Neighbour notification – Planning Application: Applicant's Name: Mr. Julian Cordy
(Not Lordy as typed on the form)

Application Number: **14/01912/F re-submission of 14/00860/F**
Proposal: **Erection of 2-storey detached domestic dwelling and division of site for proposed development**
Location: **Land adjacent to: 4 Barretts Row, Main Street, Wendlebury**

front elevation - west - new dwelling

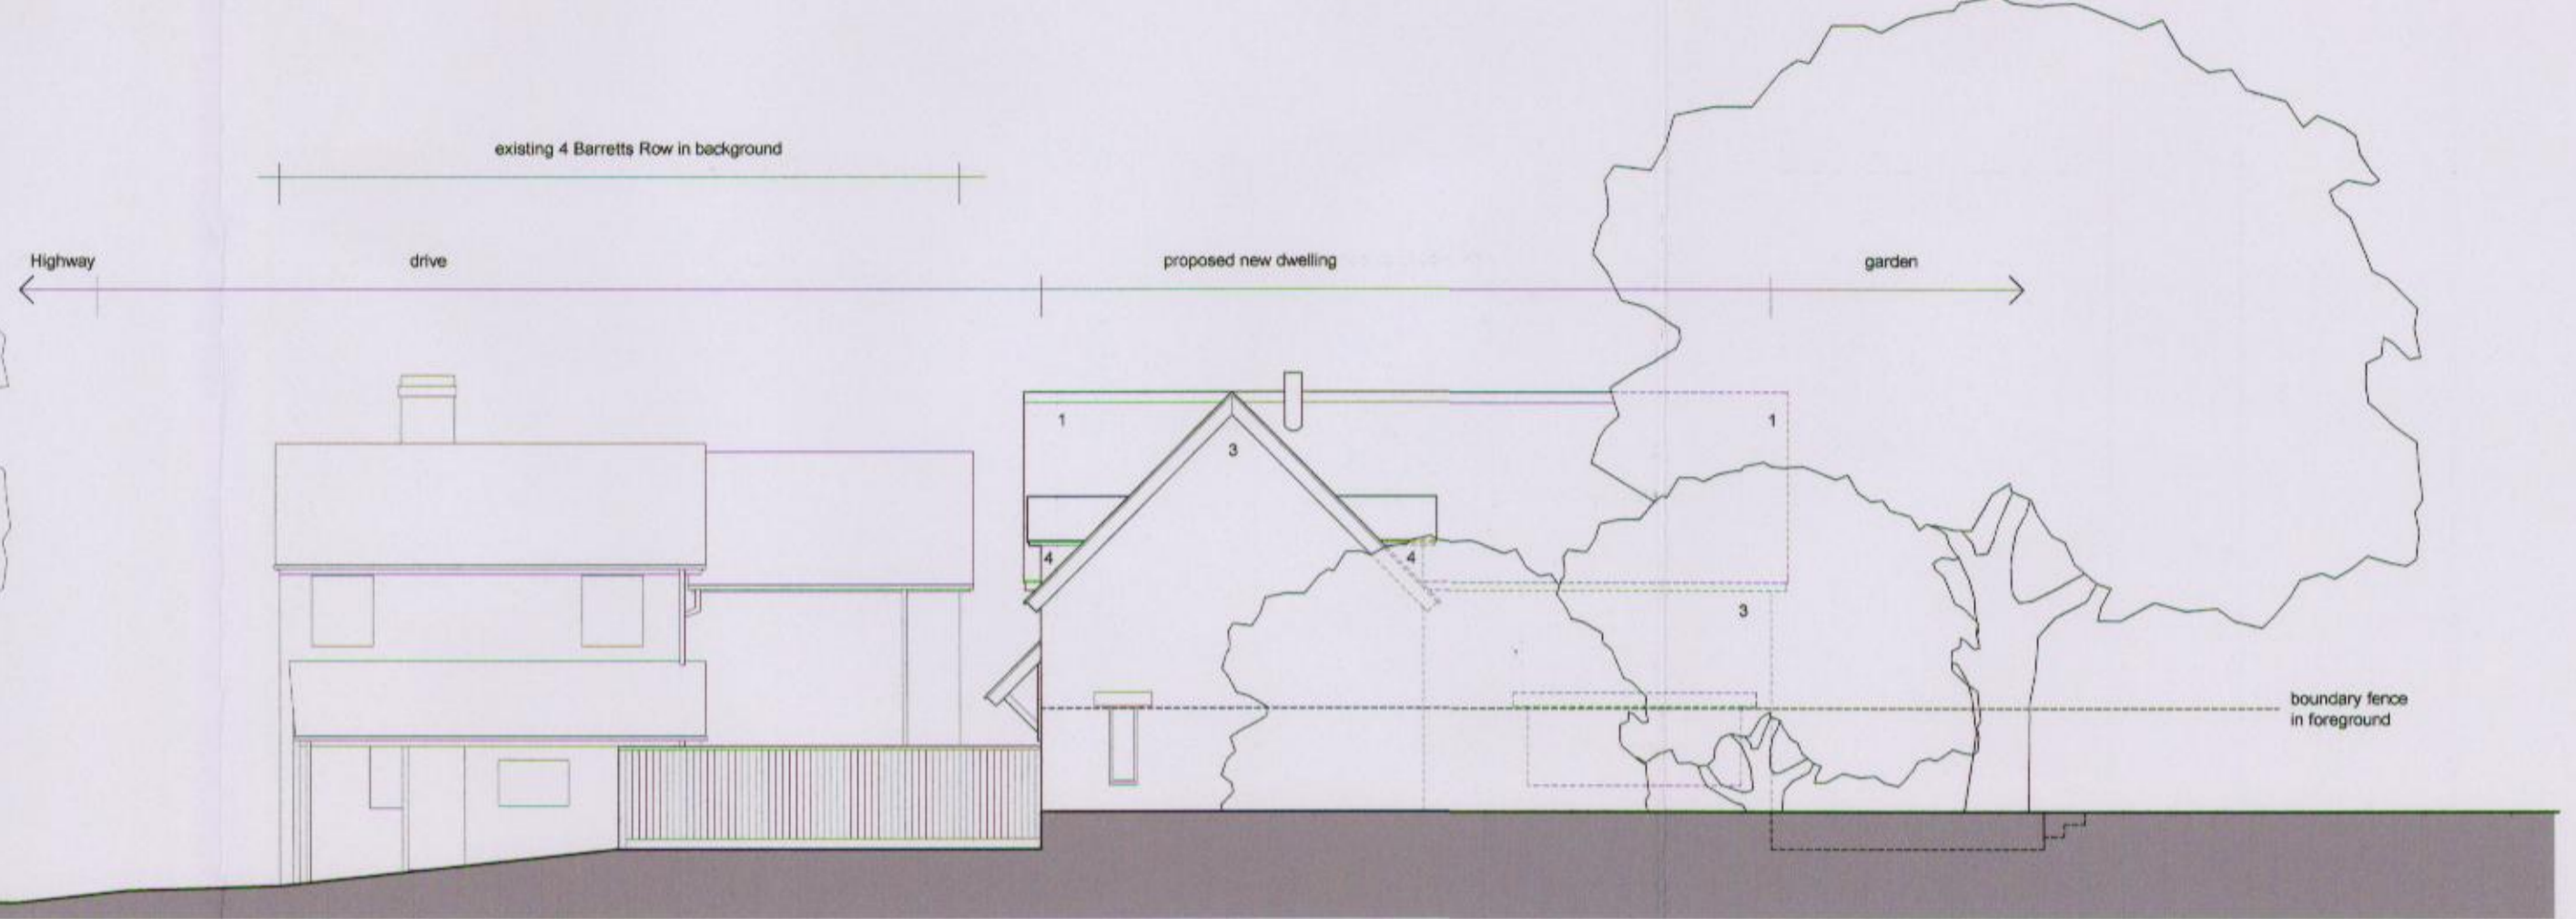
1. The front elevation (WEST) of proposed dwelling: the window sizes, in proportion to the wall, and the materials used and colour of window frames should be in harmony with the windows on the front elevation of the Red Lion Public House(LB), Elm Tree House (LB) the front of 4 Barretts Row and with our house opposite; The Laurels. **Reason:** to help maintain the visual impression of the 2 listed buildings and the older Waterside cottages opposite the Red Lion.
